Our ref: SSD-7709-PA-55

**Moorebank Precinct West Stage 2 (SSD 7709)  
Road Safety Audit – Condition B112**

I refer to the Road Safety Audit report, dated 16 July 2020, prepared by an independent Transport for NSW accredited road safety auditor (ARRB) under the conditions of consent B111 of SSD 7709.

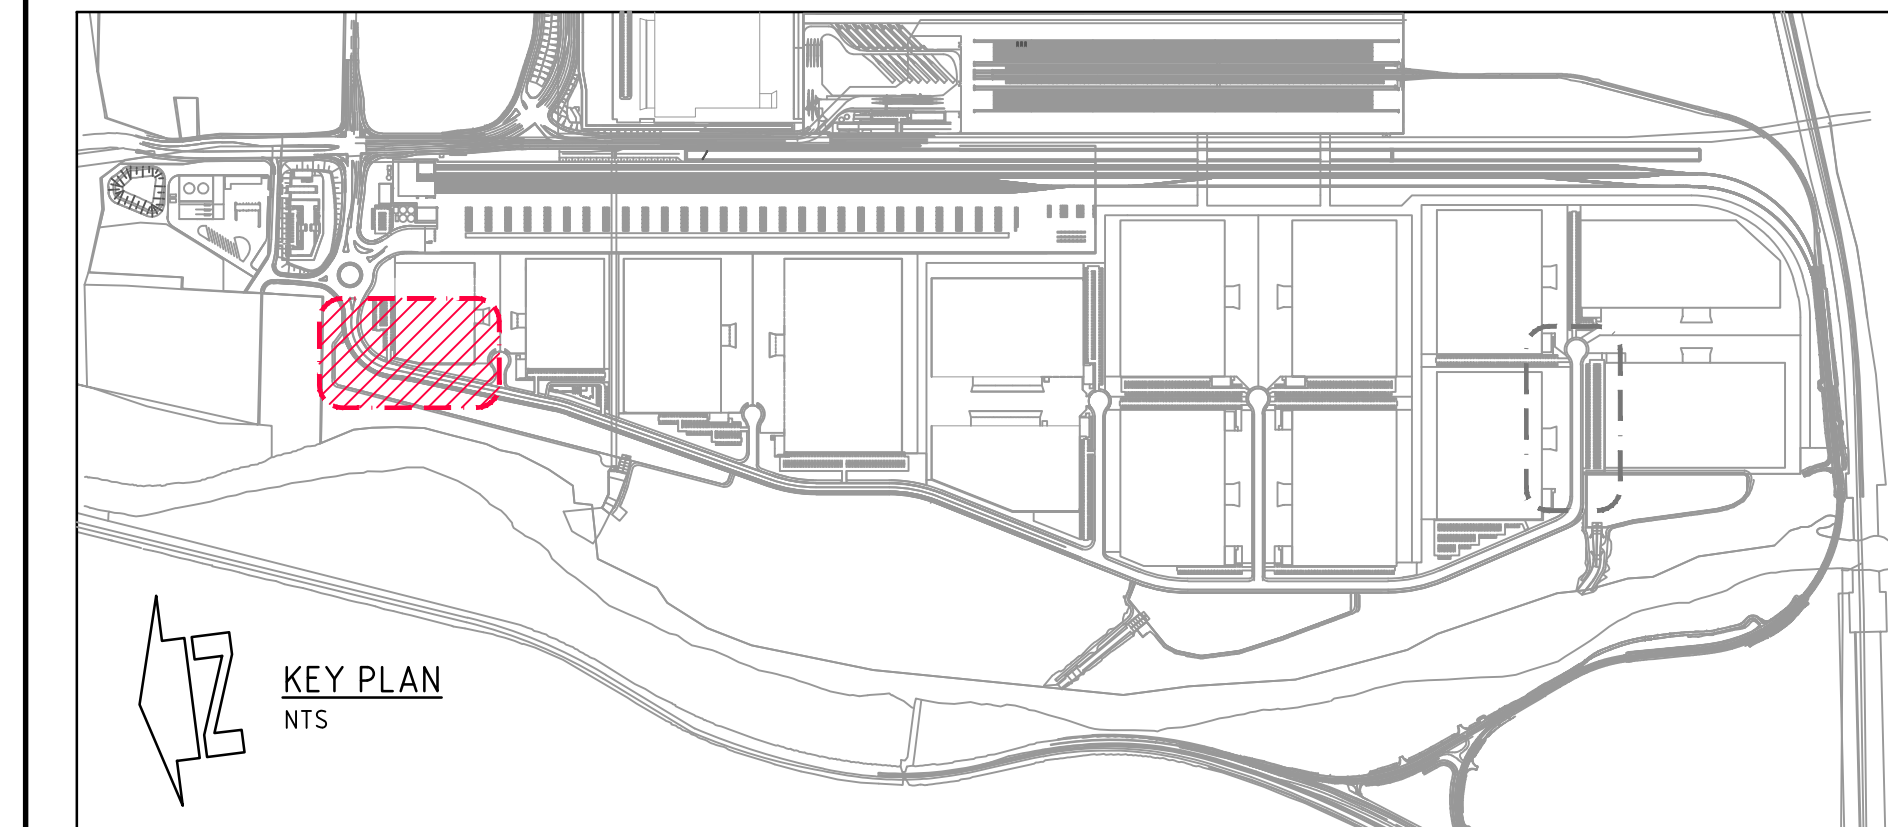
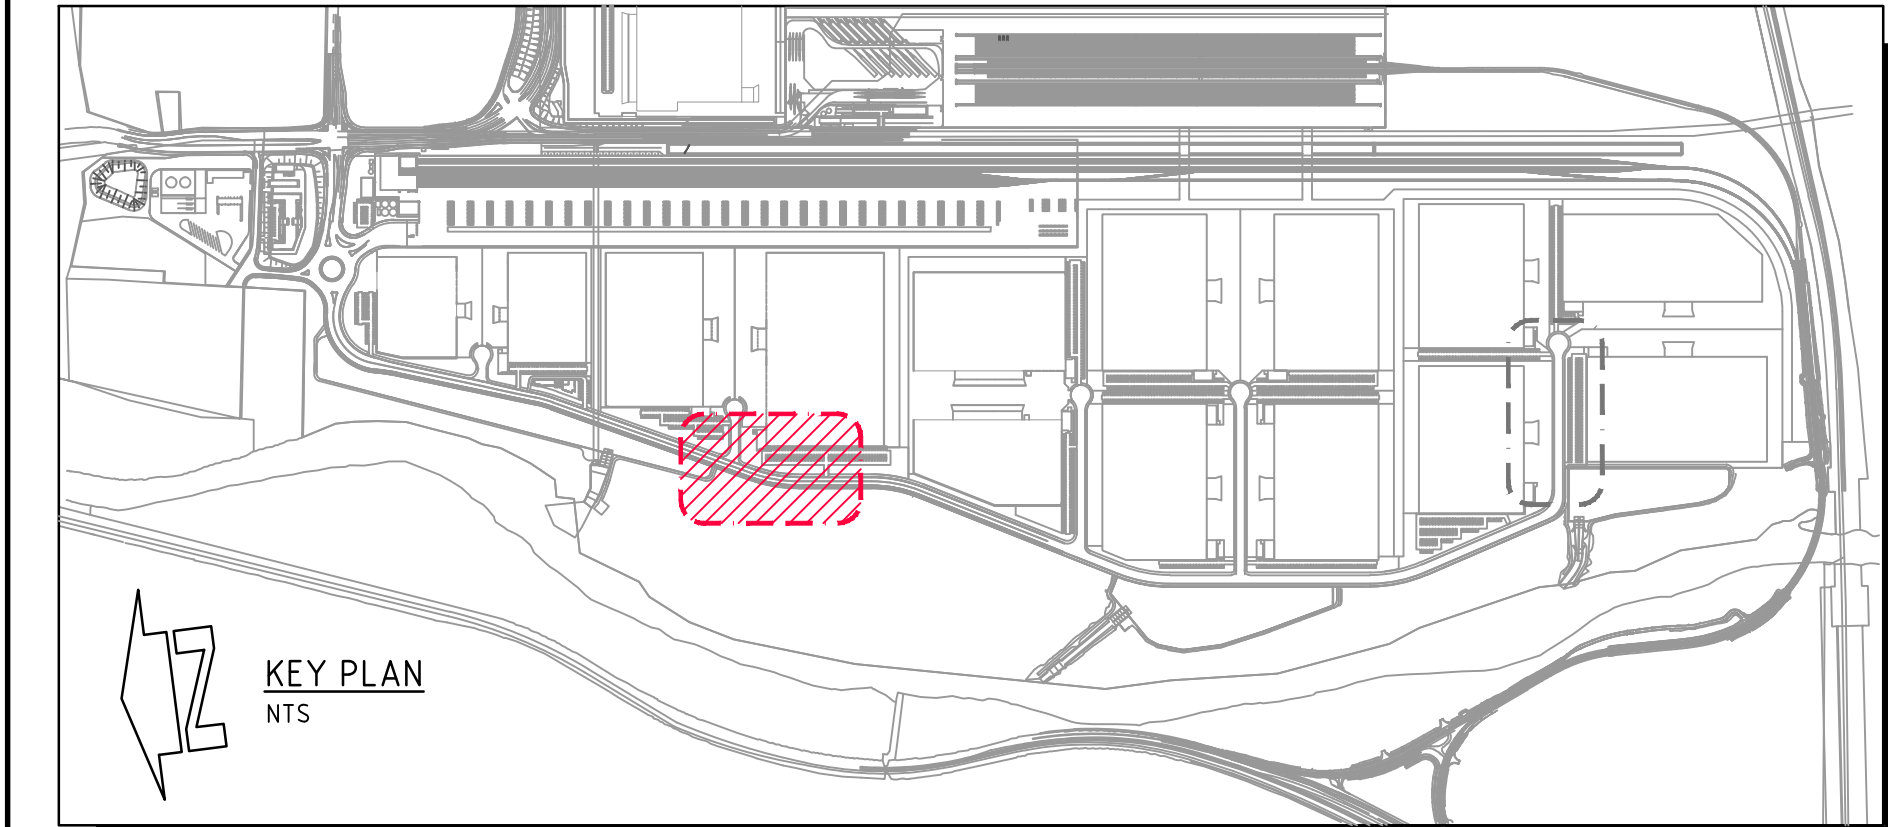
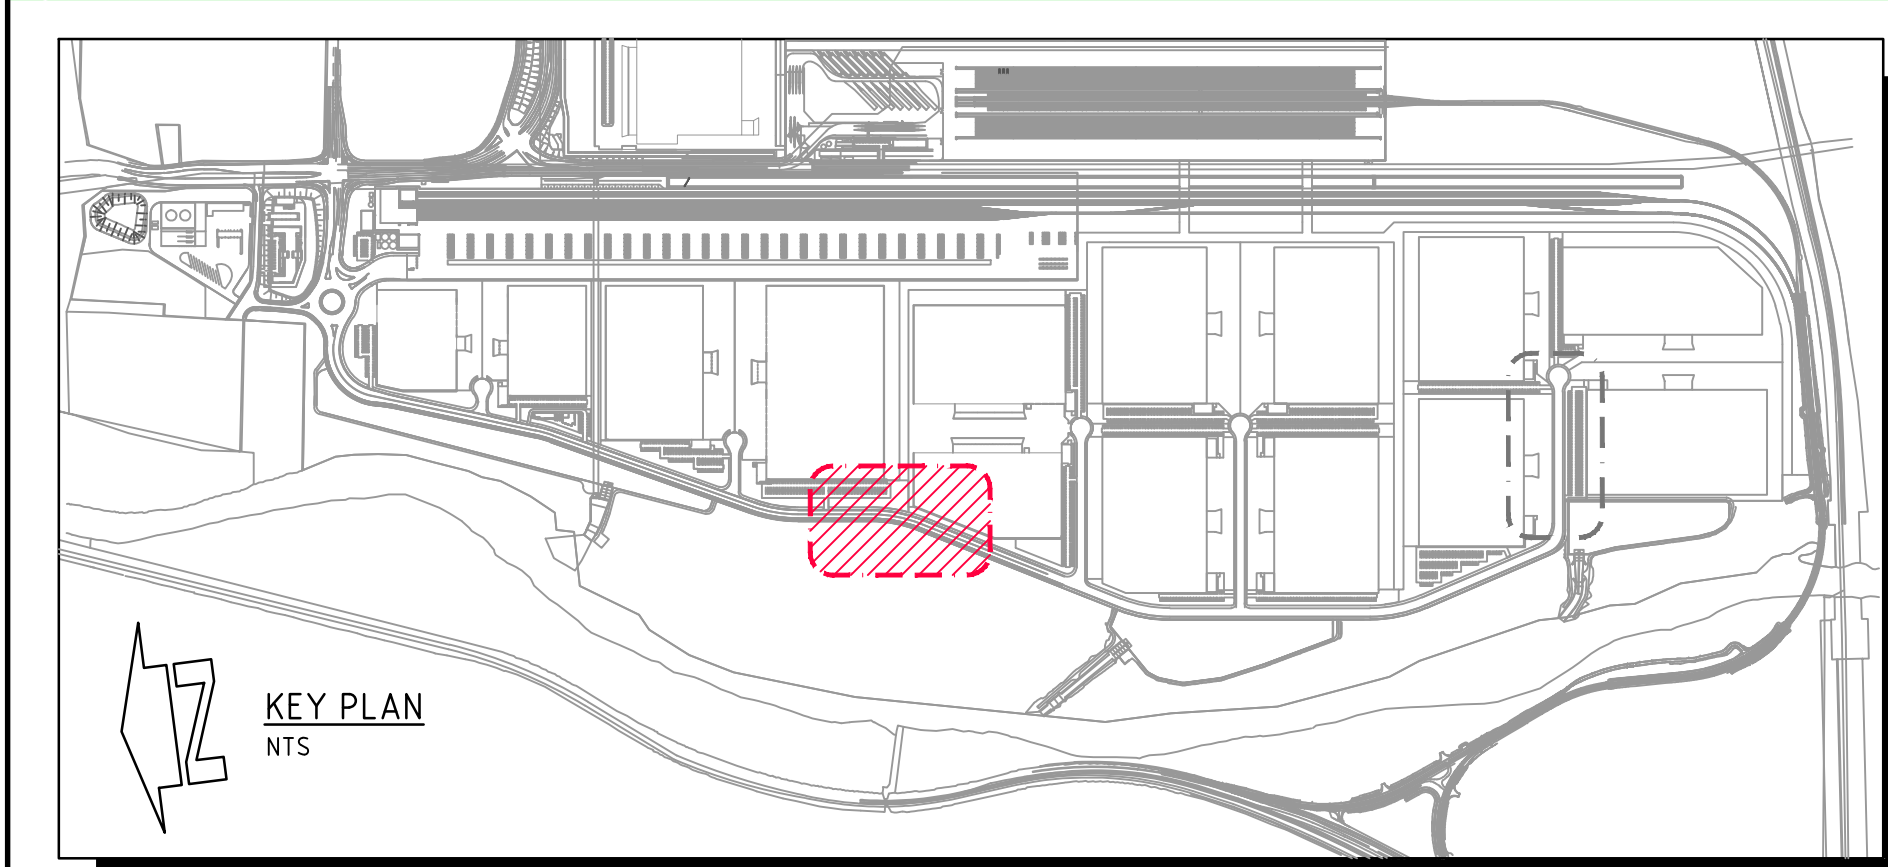
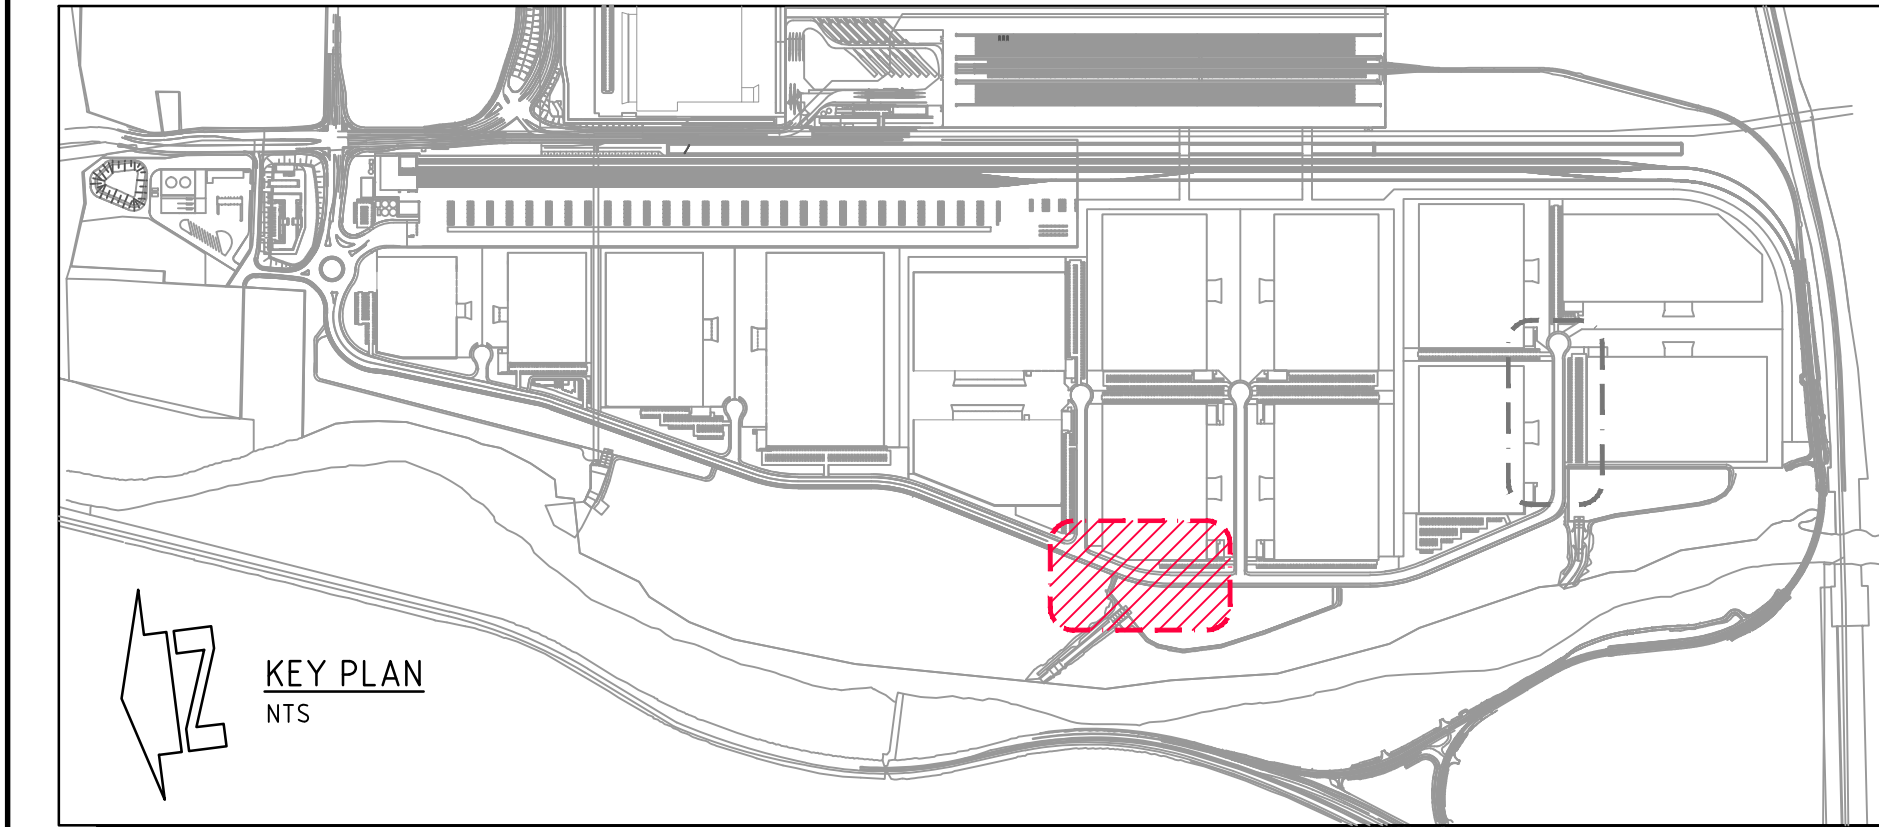
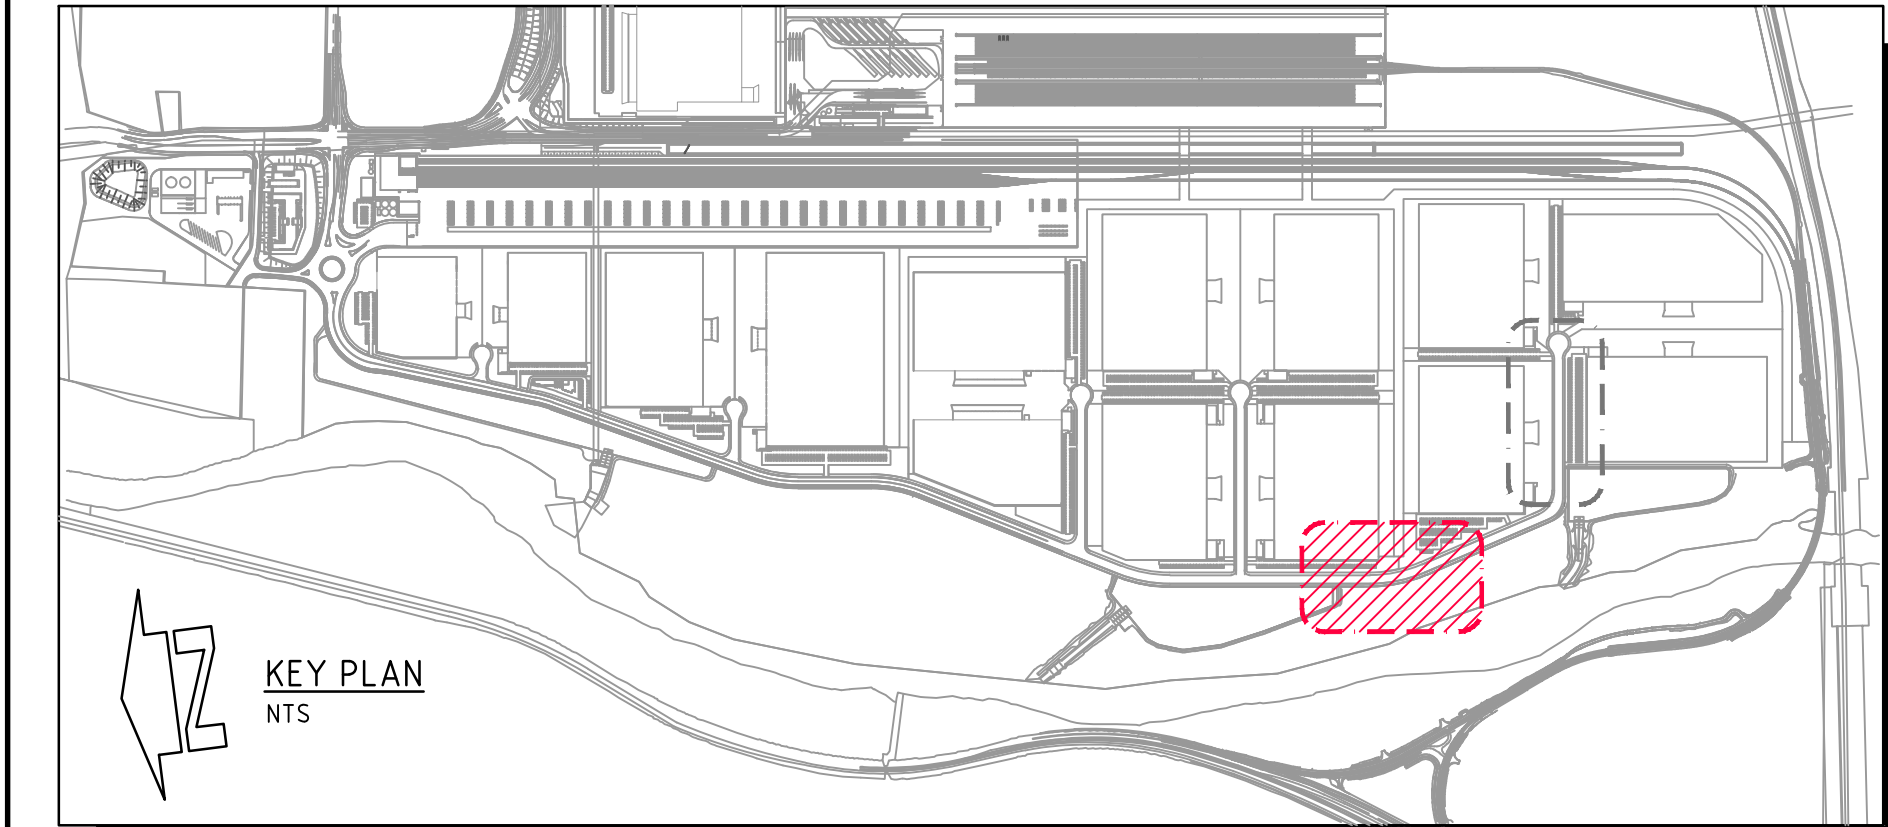
I note that the audit suggests increasing the timing for pedestrian/cyclist crossing phases by delaying the green turning arrow for motorists at the Chatham Avenue / Moorebank Avenue intersection.

In your correspondence dated 12 October 2020, you advised the Department that no corrective action will be taken due to a lack of pedestrian connectivity south of this intersection.
